From: Roger Spencer <Roger.Spencer@arun.gov.uk>
Sent: 13 April 2022 15:13
To: Simon Davis <Simon.Davis@arun.gov.uk>
Cc: Karl Roberts <Karl.Roberts@arun.gov.uk>; Paul Cann <Paul.Cann@arun.gov.uk>; Sarah Burrow <Sarah.Burrow@arun.gov.uk>
Subject: Y/38/22/DOC 0 Drove Lane Yapton

There were three issues outstanding relation to the discharge of this condition.

CLIENT BARRATT DAVID WILSON HOMES			DWG. TITLE TREE PIT DETAIL IN SOFT LANDSCAPE NEXT TO PCC EDGE WITH ROOT BARRIER			
PURPOSE OF ISSUE PLANNING STAGE						
SITE YAPTON, DROVE LANE						
DRG BY AJW	CHECKED JBA	AUTH'D JBA	SCALE 1:20@A3	DATE FEB 2022	DWG NO. JBA 19/291 -DT2	REV. .

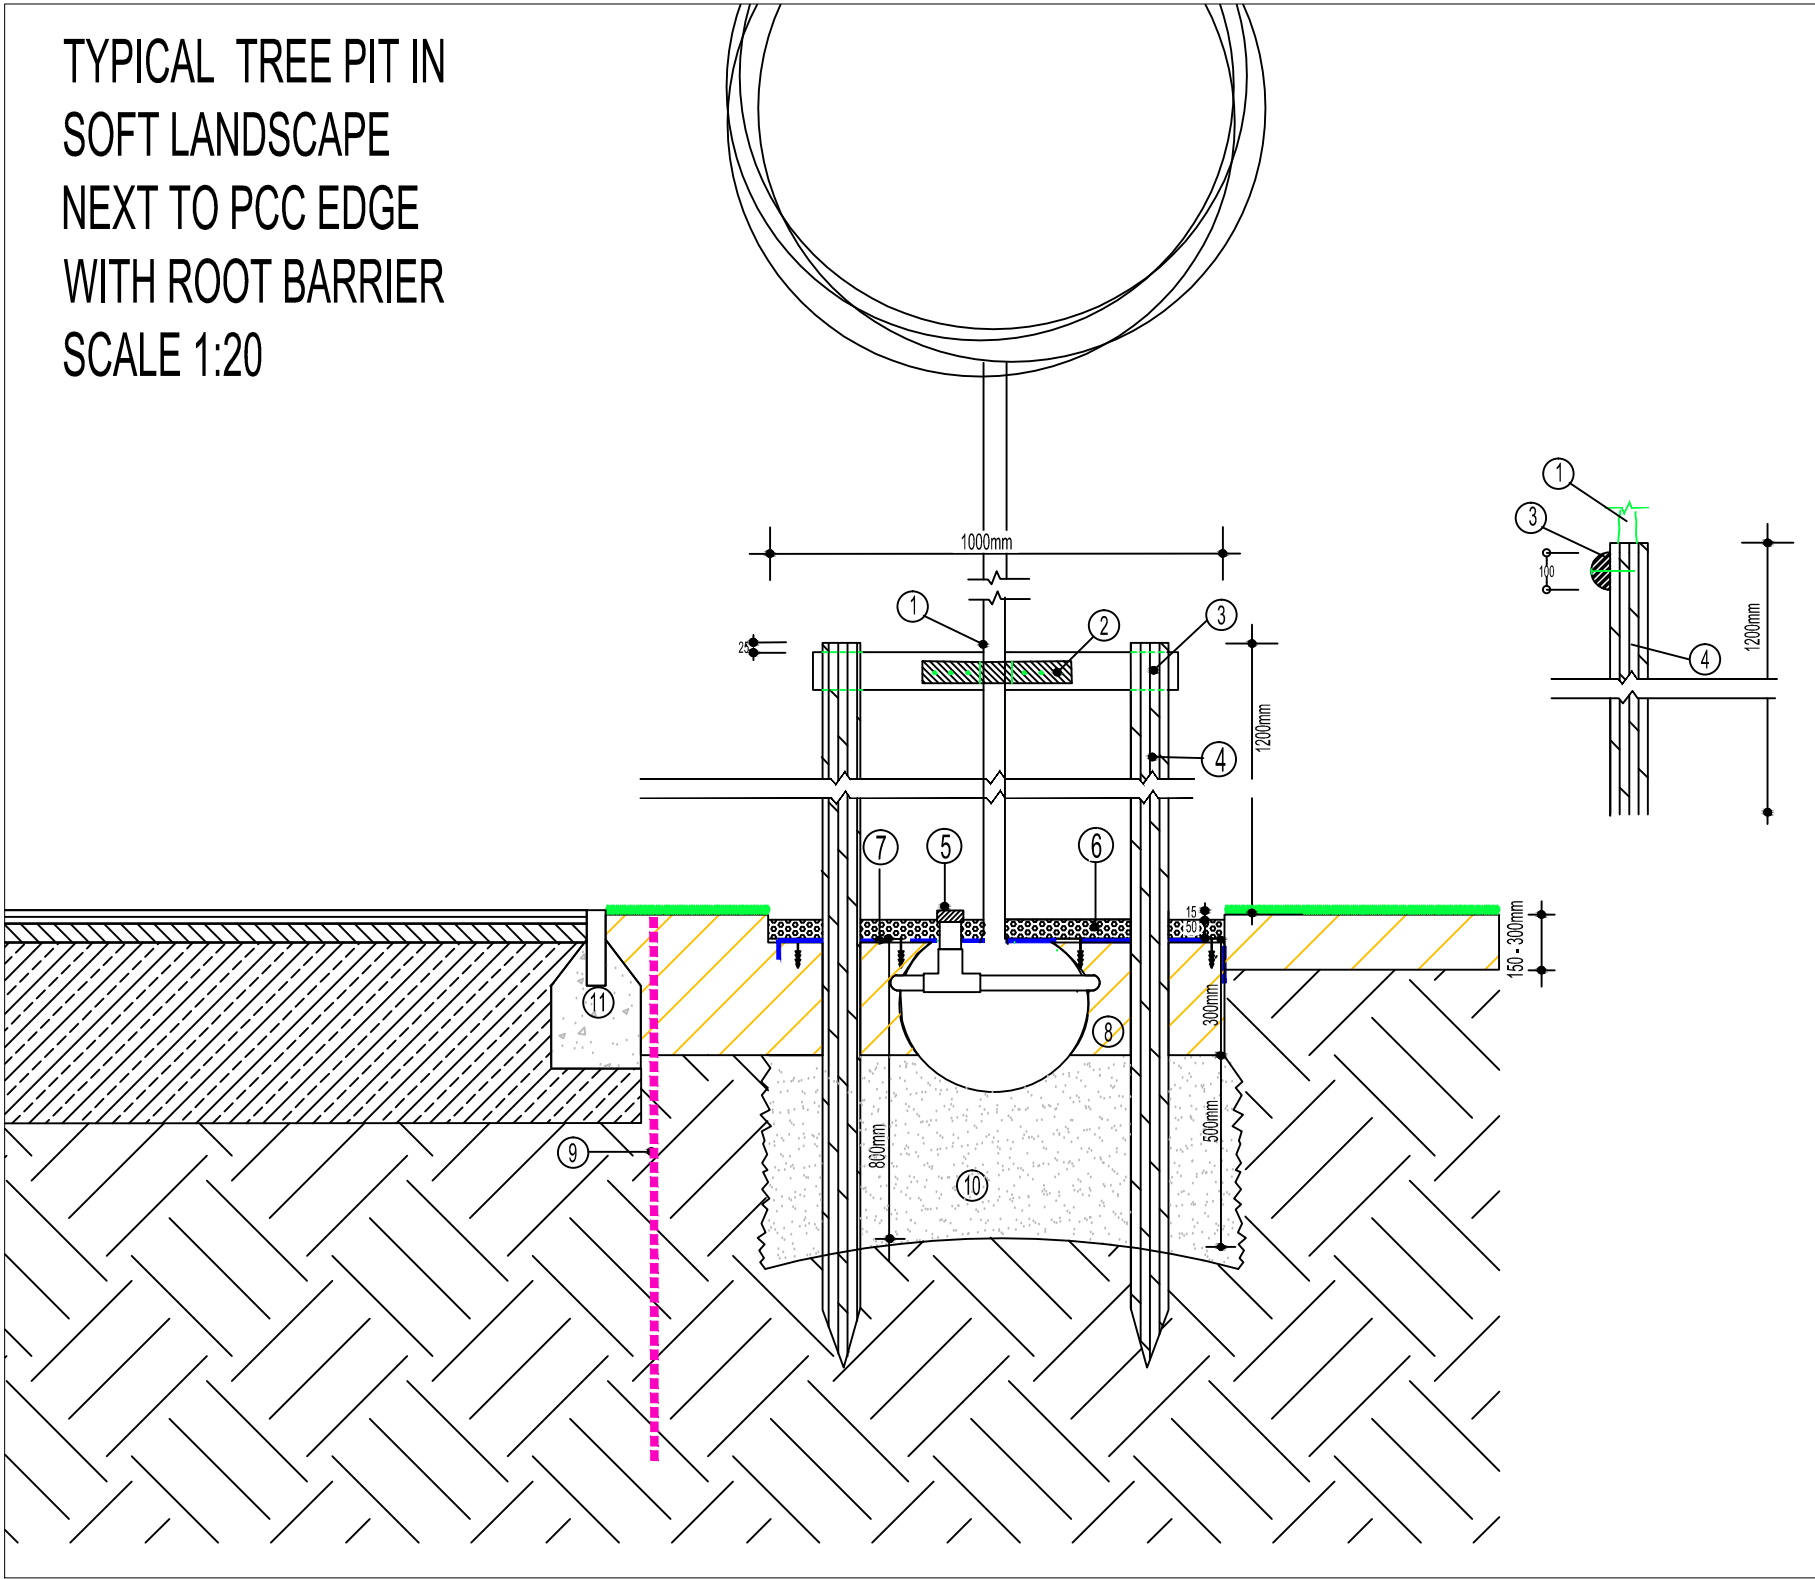
The first was in relation to tree <> drainage interaction. Root protection barriers have been proposed and these are acceptable.
